**Town & Country Planning Act 1990 (as amended)
Town & Country Planning (Development Management Procedure) (England) Order 2015
Application for Householder Planning Permission**

Development Balcony over bay window. This application may affect the setting of a listed building & affects the character & appearance of the Upper Bognor Road & Mead Lane Conservation Area.

Location 51 Mead Lane Bognor Regis

BLOCK PLAN 1:500.

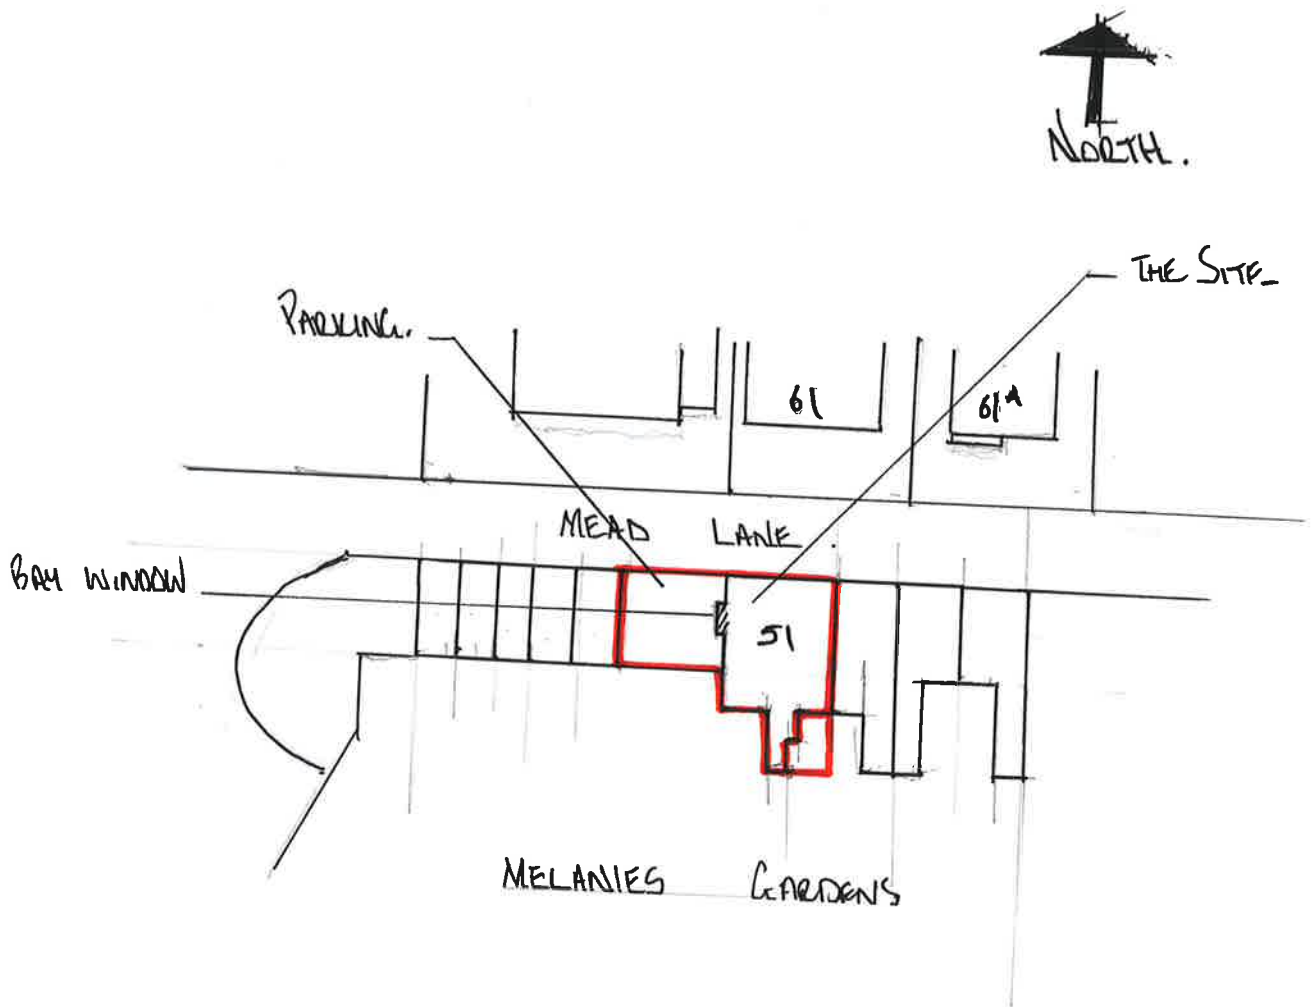
Block Plan

The block plan submitted on 18/02/2020 is for the incorrect site. Please provide the correct block plan, including all details on the block plan in accordance with the National and Local Validation Criteria.
